15 March 2021

Our Ref: 188530

RE: SSD-10421 Weigall Sports Complex, Sydney Grammar School

TITLE				
STORMWATER KEY PLAN				
SCALE	DRAWN	DESIGNED	CHECKED	APPROVED
AS SHOWN	M.T.	M.Cz.	L.S.	L.S.
JOB No.		DRAWING No.		ISSUE
6817000		C6.01		3
DATE		STATUS		
SEPTEMBER 2020		SSDA

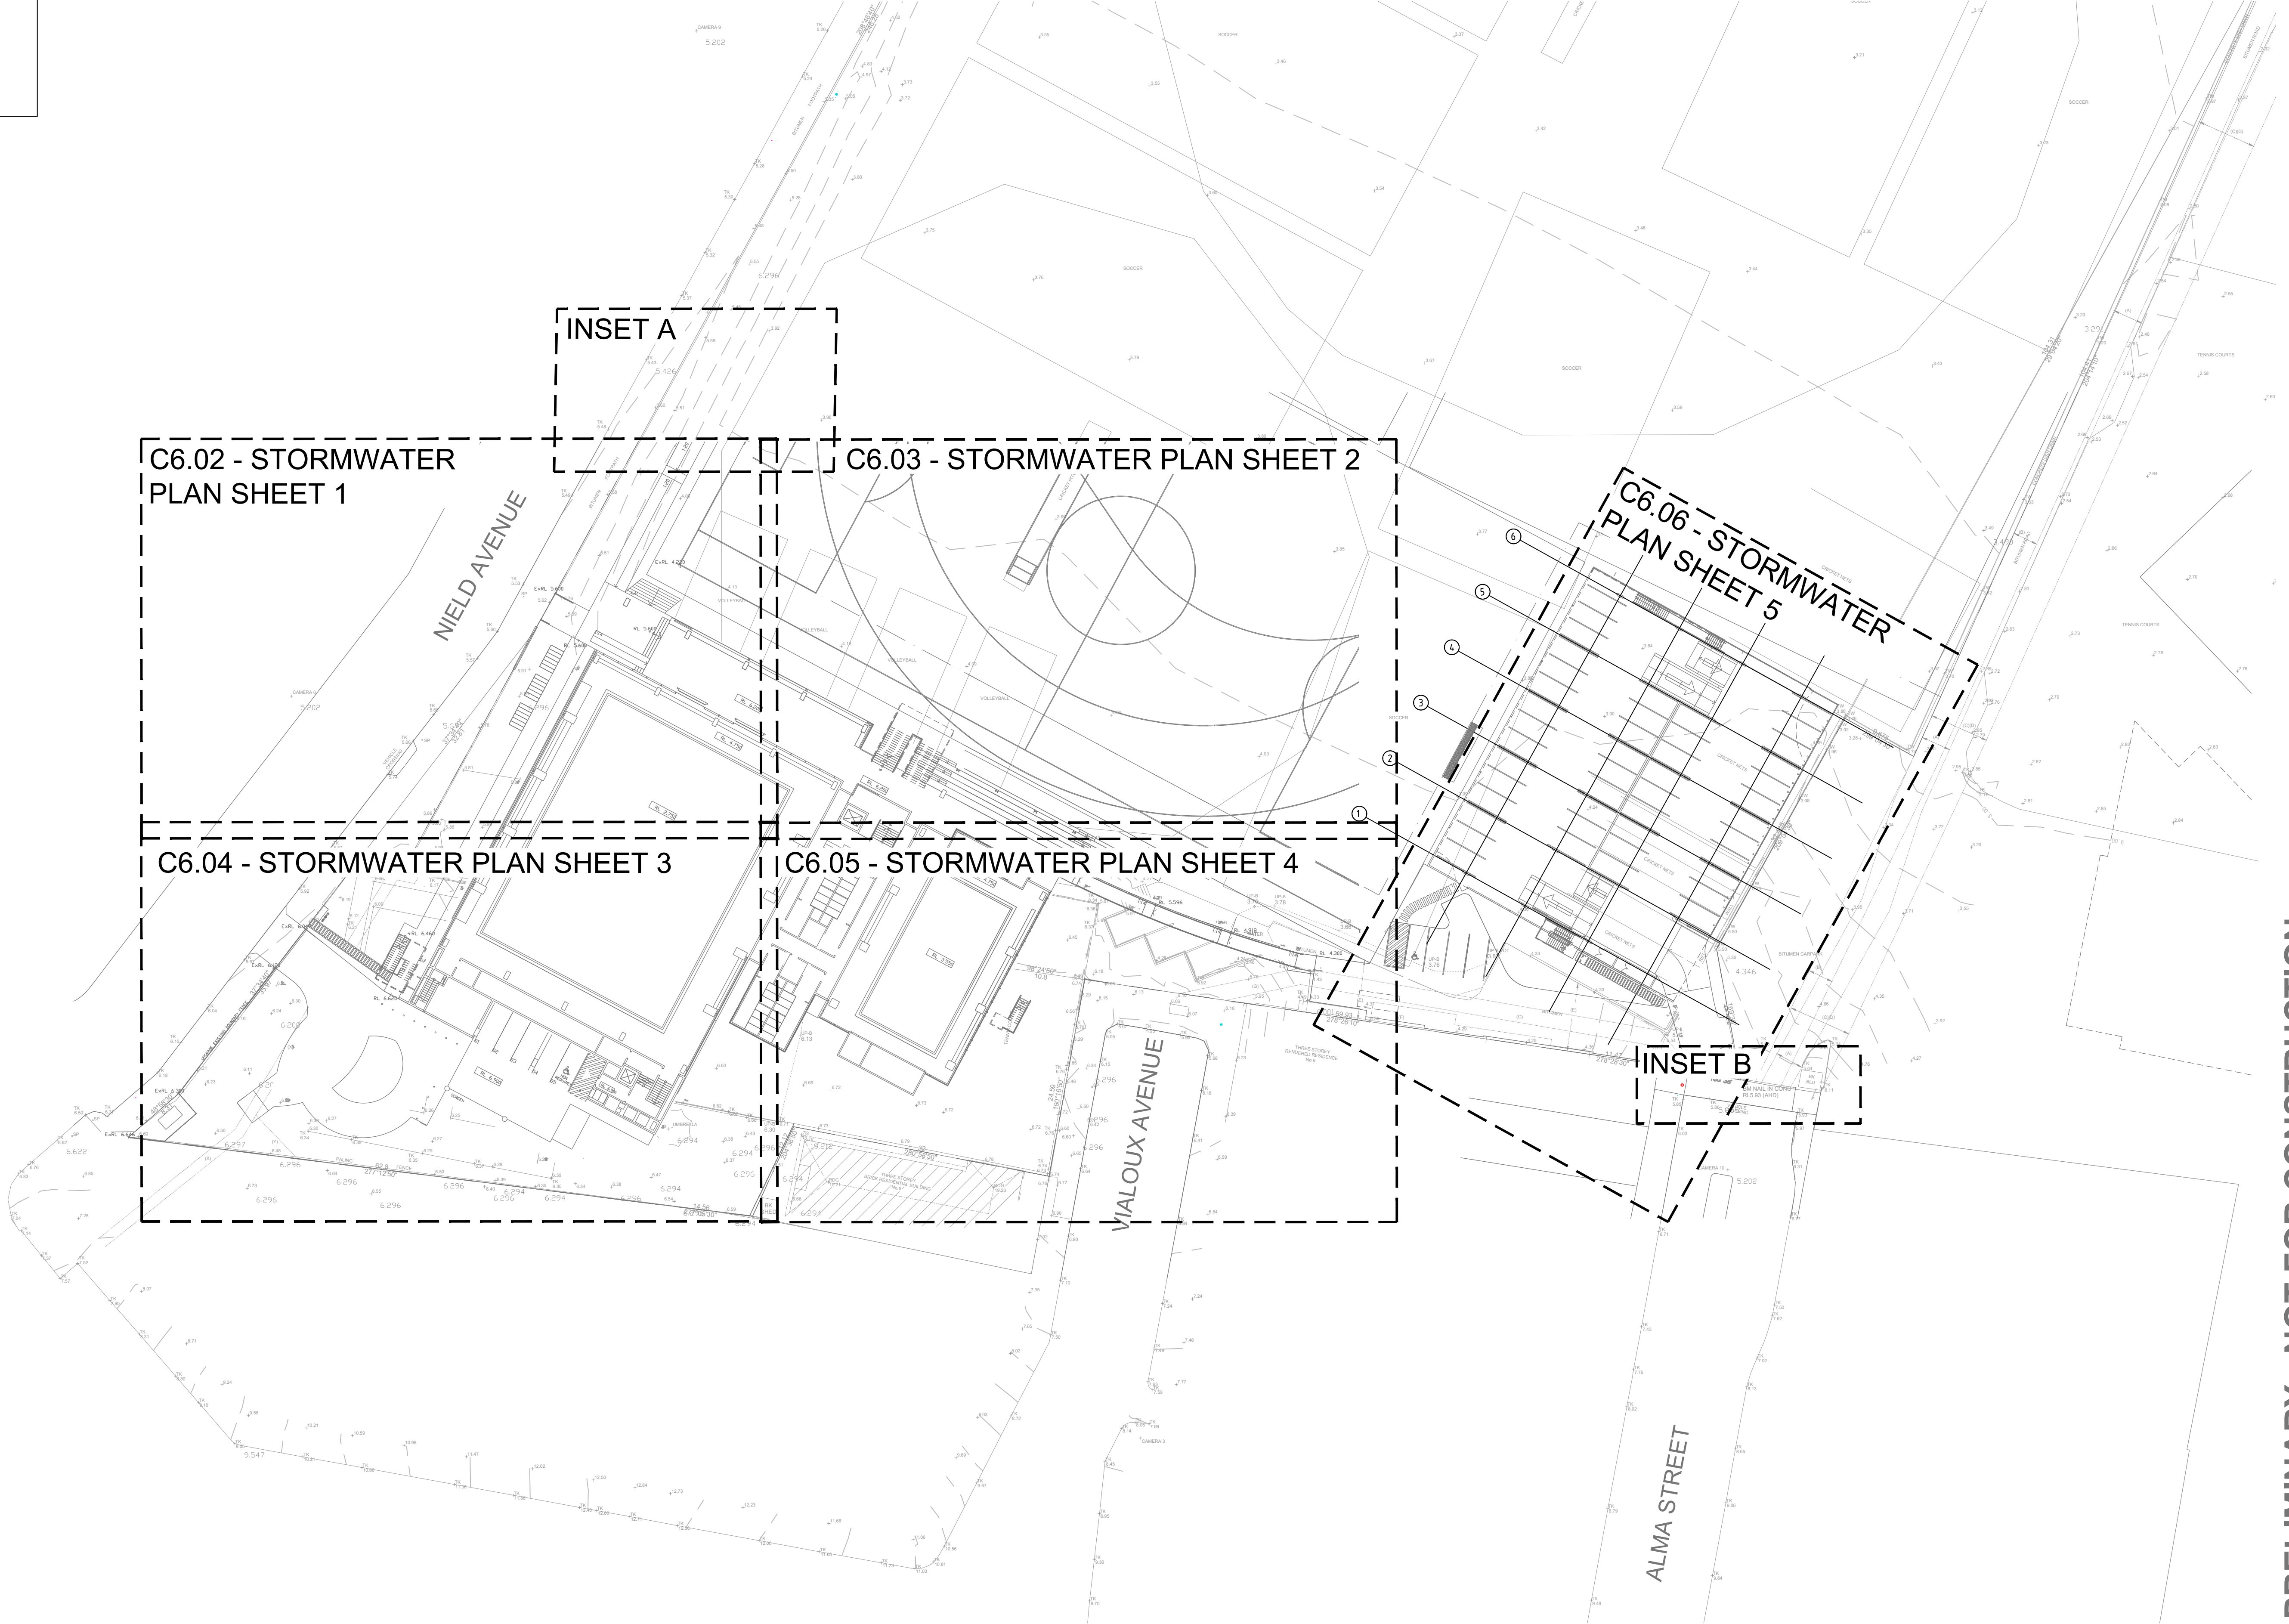
- Sydney Water has issue with the proposal in its current format as it appears that there are buildings and permanent structures proposed over its stormwater channel or within 1m from the outside face of the stormwater channel.

- Our available records indicate Sydney Water's major 860mm x 990mm stormwater channel is located within the development site. **The proponent must provide evidence that their buildings and permanent structures are 1m away from Sydney Water's stormwater channel or need to revise their proposal** to ensure no buildings or permanent structures are proposed over its stormwater channel or within 1m from the outside face of the stormwater channel. Permanent structures include (but are not limited to) basement car park, hanging balcony, roof eaves, hanging stairs, stormwater pits, stormwater pipes, elevated driveway, basement access or similar structures. This clearance requirement would apply for unlimited depth and height.

- Please also note that any ground level treatment where the quality of the final ground surface is above the quality of standard foot path, such a treatment will not be permitted within the 1m clearance zone of stormwater assets (eg: no tennis court or any artificial turf).
